Re: Integra Mine Complex Modification 2 – Response to Submissions

Table 1 Response to submissions on Integra Mine Complex Modification 2

Figure 1 - Conveyor transport only, Leq (15-min), dB(A) inversion meteorological conditions

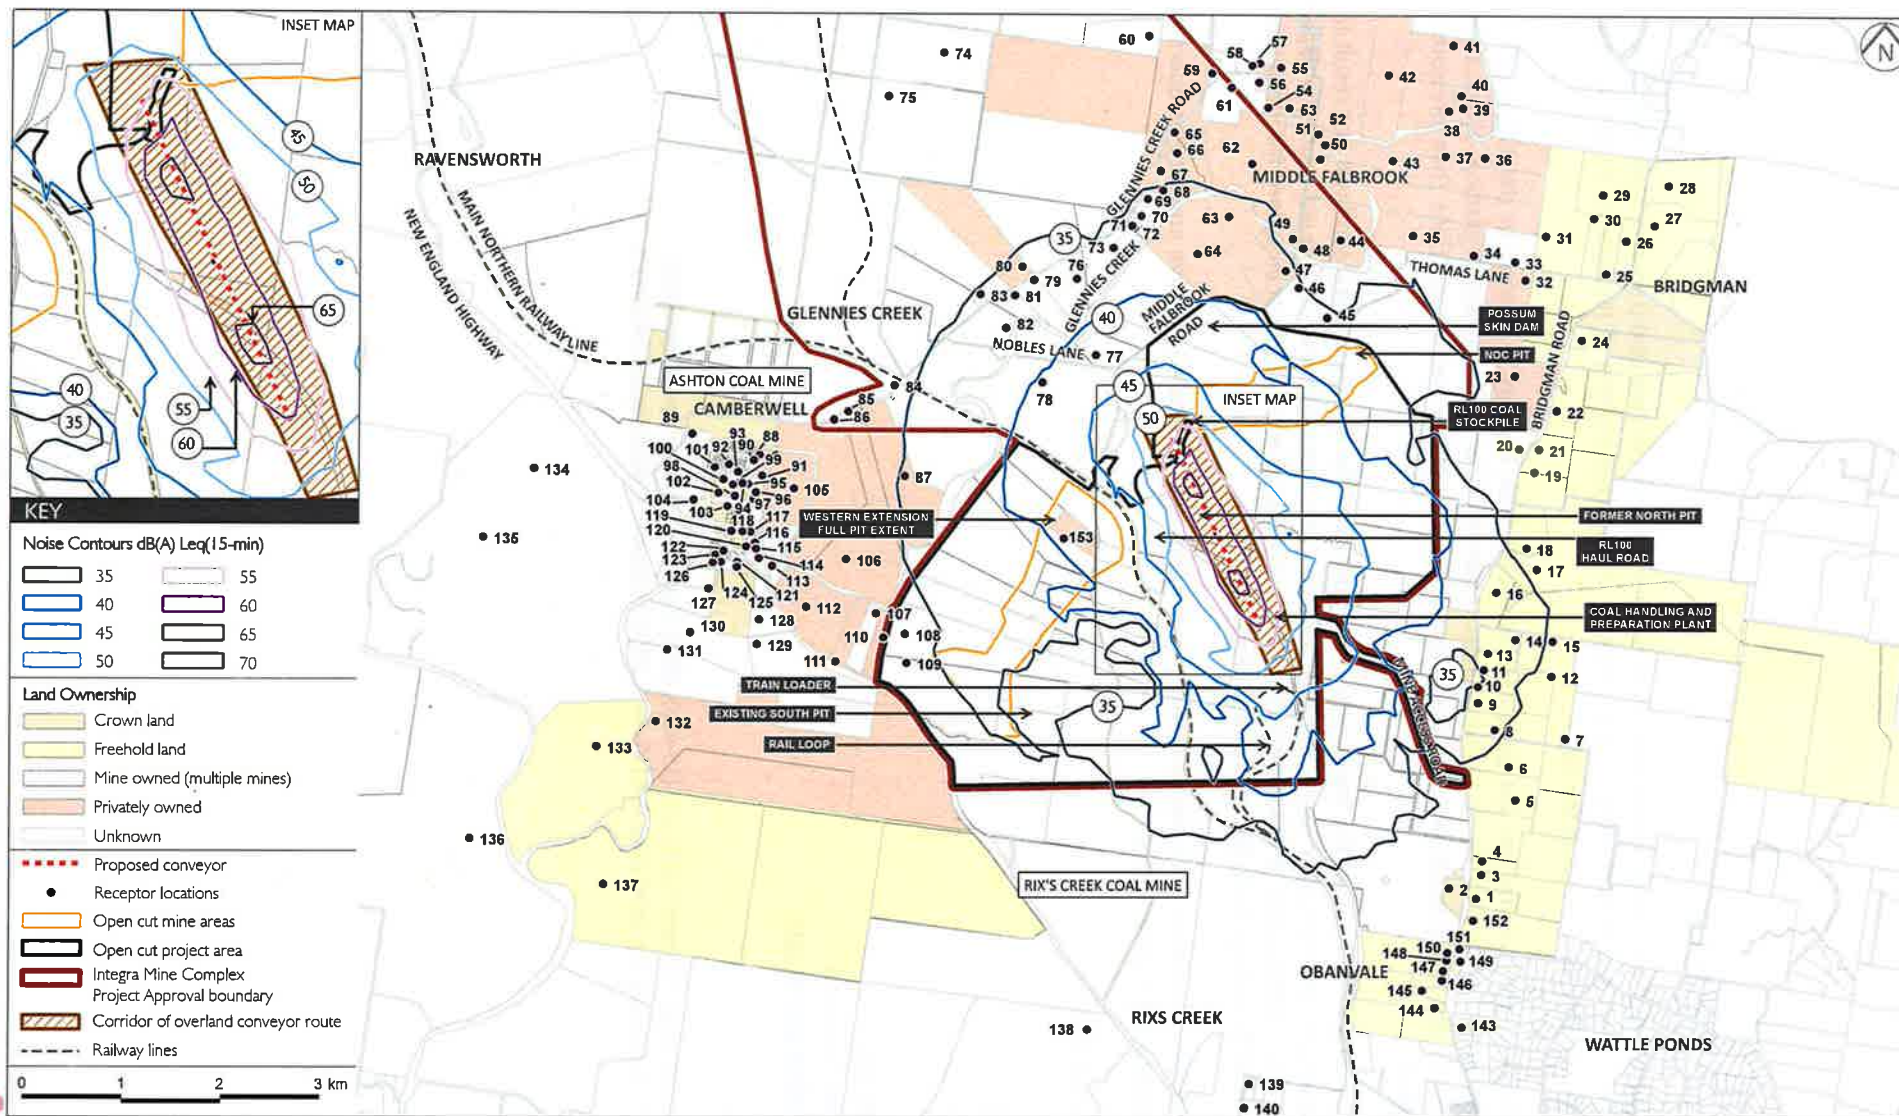
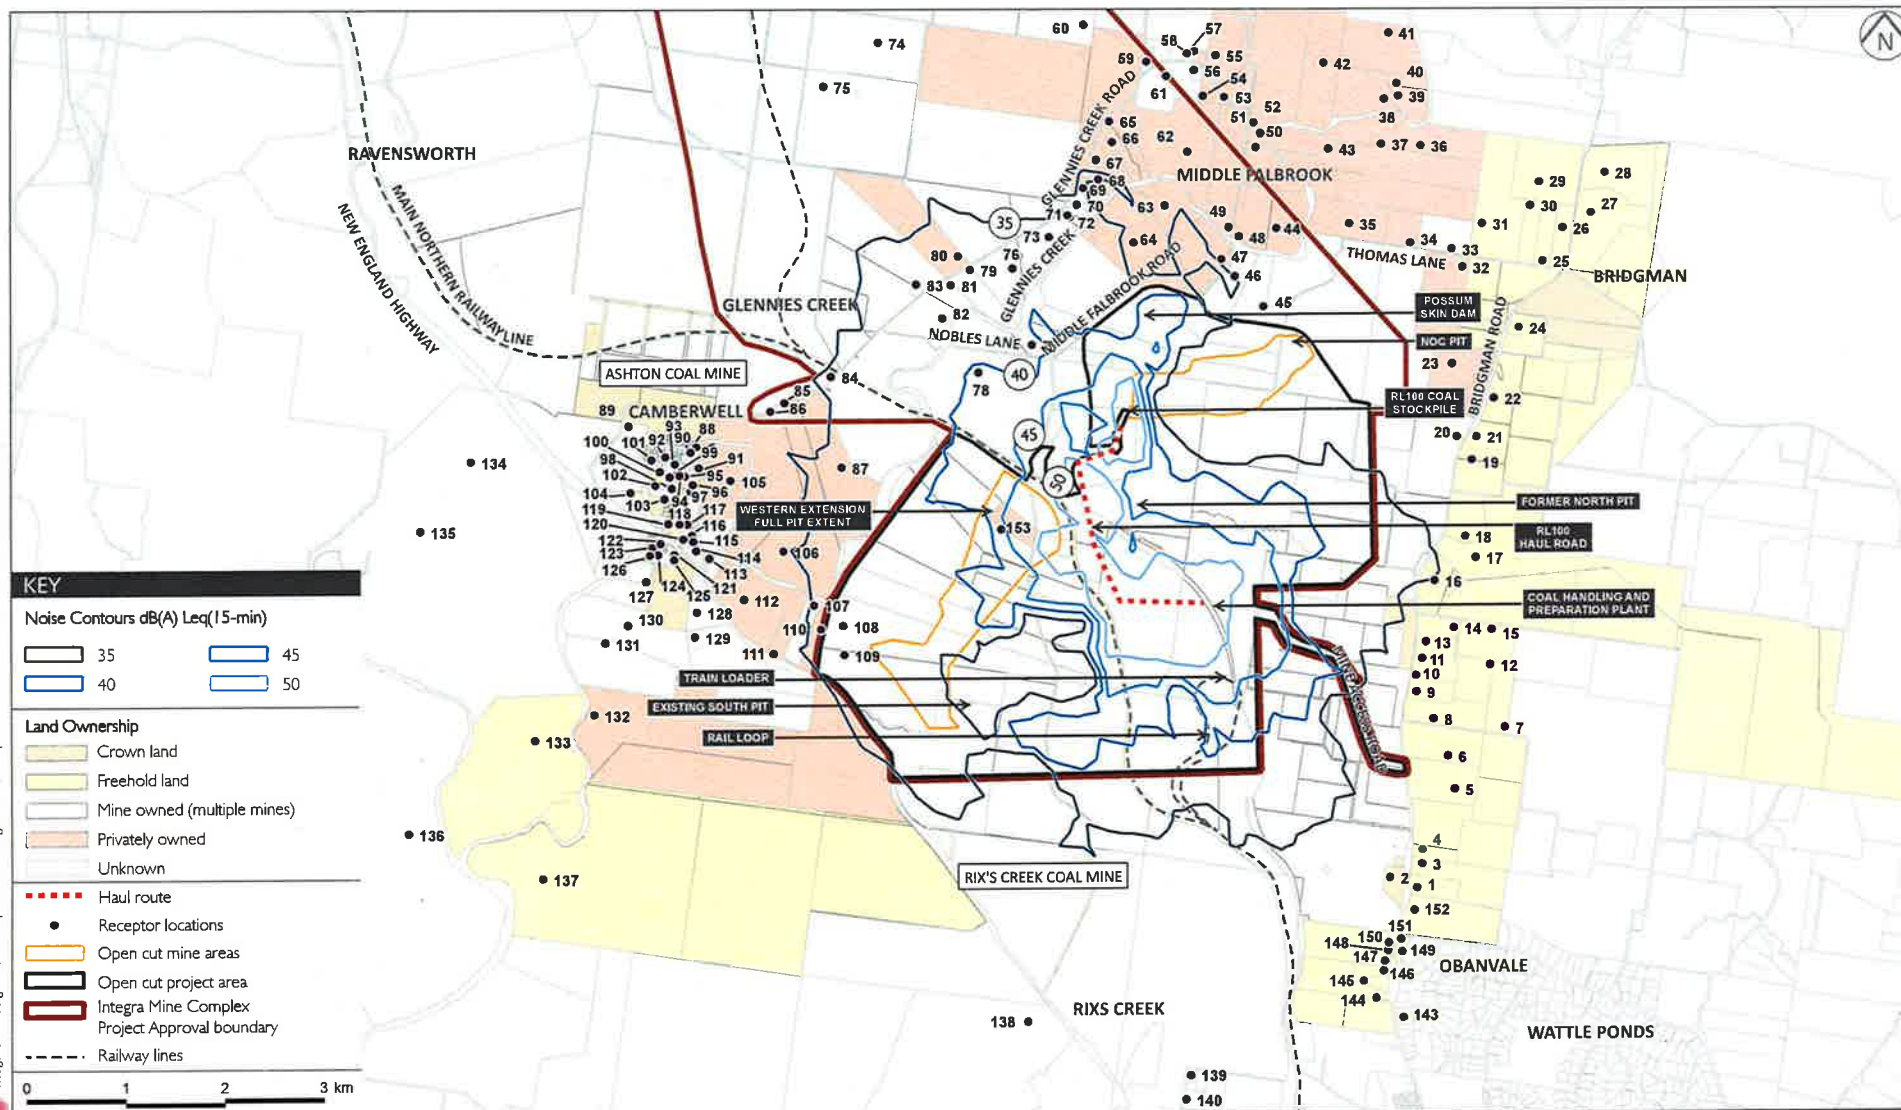
Submission reference	Matters raised in submission	Response
	to air quality.	
G2.2	The EA includes in Appendix C the modelling results which compare the noise levels of the conveyor option against the haul truck option. There is little detail in the EA on the modelling methodology and it appears that the 'criteria' listed in the Tables in Appendix C are not the same as the noise limits in the Project Approval. This makes it difficult to assess compliance or otherwise with the noise limits if haulage by trucks was maintained over constructing the conveyor.	The noise impact assessment in Appendix C of the EA was completed prior to the Project Approvals being released. Therefore, the assessment adopted the original project specific noise levels, identified in Heggies 2009, which formed the basis of the Project Approval limits. For the majority of receivers, the criteria adopted for the comparison assessment were lower than the Project Approval criteria, resulting in a more conservative assessment. A primary objective of the noise impact assessment was to assess the change in noise levels from the continued truck haulage compared to the operation of the overland conveyor. The noise impact assessment showed that there would be no increase in noise levels as a result of continued truck haulage with the construction of a 3 m bund along the haul road. Therefore, compliance with noise levels is consistent with the approved operations.

G2.3	It appears from the noise levels in Appendix C that some properties will be worse off by continued haulage by trucks compared with the conveyor, however the discussion in Appendix C indicates that modelling did not include the 3 m bund which the EA states has now been constructed. As predicted noise levels are not provided for operations with and without the bund, it is not clear what benefit the 3 m bund will have for those receivers who may have benefited from the conveyor. EPA considers that the onus is on the proponent to achieve the noise limits in the existing Project Approval (and Environment Protection Licence (EPL)).	Unmitigated truck haulage was expected to result in noise levels 1 to 2 dB(A) higher than the conveyor scenario. Consequently, a 3 m bund wall was constructed to mitigate noise levels from the truck haulage. The bund wall was predicted to decrease noise levels of between on the RL100 haul road used for truck haulage by approximately 5 dB(A). The continuation of road haulage with construction of the bund will, therefore, not result in an increase in noise levels and will have decreases in noise levels for receptors situated in Noise Assessment Group (NAG) 10 and potentially at NAG 9 compared to the conveyor scenario. Compliance with the noise limits in the Project Approvals and EPL will be monitored through implementation of Integra's Noise Management Plan (NMP) which includes a comprehensive noise monitoring network. The NMP includes attended and unattended monitoring, both of which can quantify cumulative mining noise. Continuous unattended monitoring will be undertaken at four real time noise monitors which are alarmed to notify relevant Integra personnel of unfavourable noise conditions or levels. The NMP includes preventative measures which aim to minimise the likelihood of a noise exceedence occurring and corrective measures which aim to minimise the environmental impact in the event of a noise exceedence occurring. The NMP will be implemented at Integra once approved by DP&I.
